**Our Ref: AW/90/18/HH**  
**Your Ref:**

**Town & Country Planning Act 1990 (as amended)**  
**Town & country Planning (Development Management Procedure) (England) Order 2015**  
**Application for Planning Permission for Works or Extension to a Dwelling**

**Development** Two storey rear extension & first floor extensions to front & side.  
**Location** 8 Merton Close Aldwick

BLOCK PLAN PROPOSED 1:500

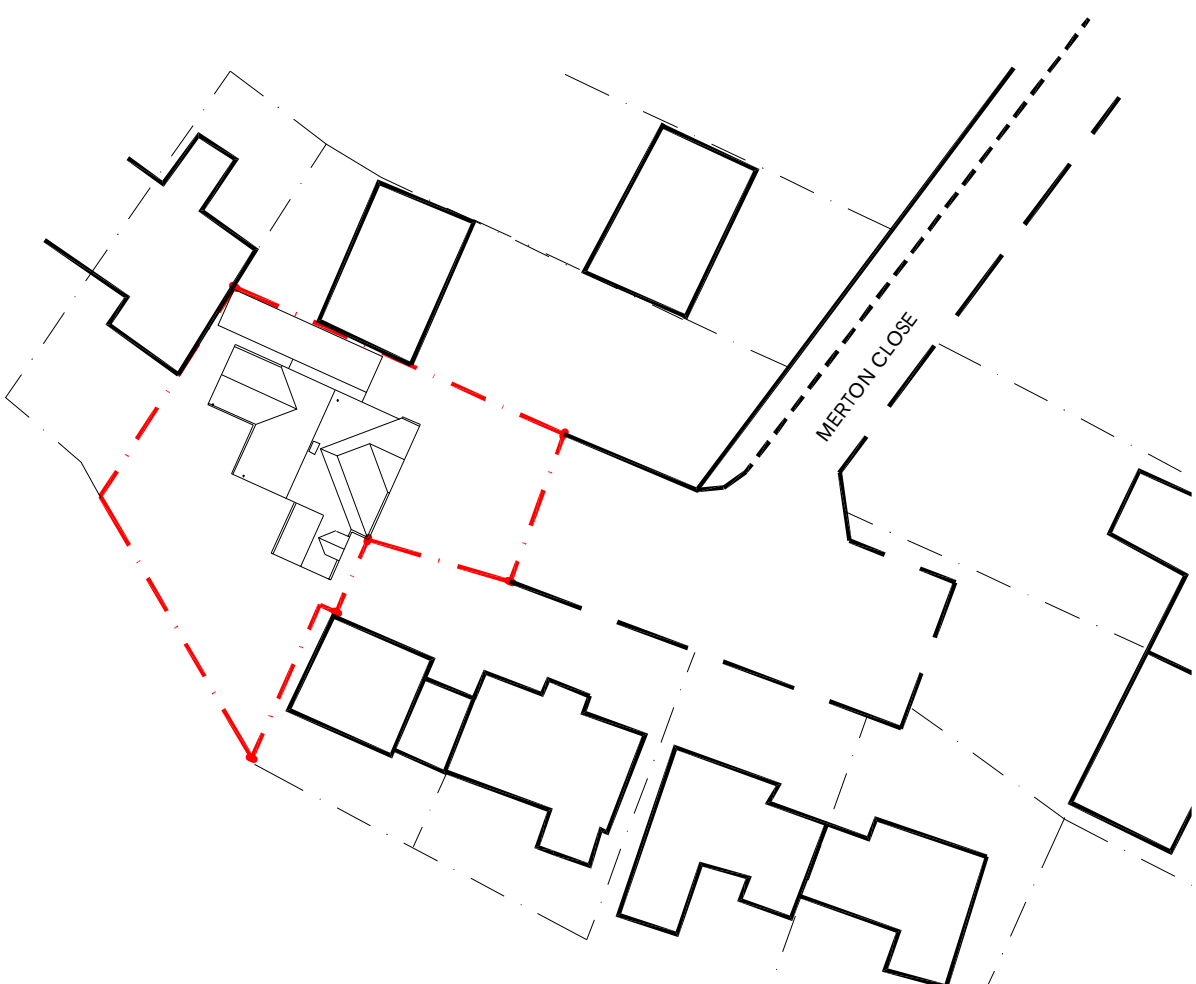
Block Plan Amend

Please submit 1 electronic or 3 paper copies of a block/site plan at a scale of 1:500 or 1:200. Further details of what must be included on the plan can be found in the National Validation Requirements. Please highlight all proposed works and provide measurements from the proposals to the site boundaries.
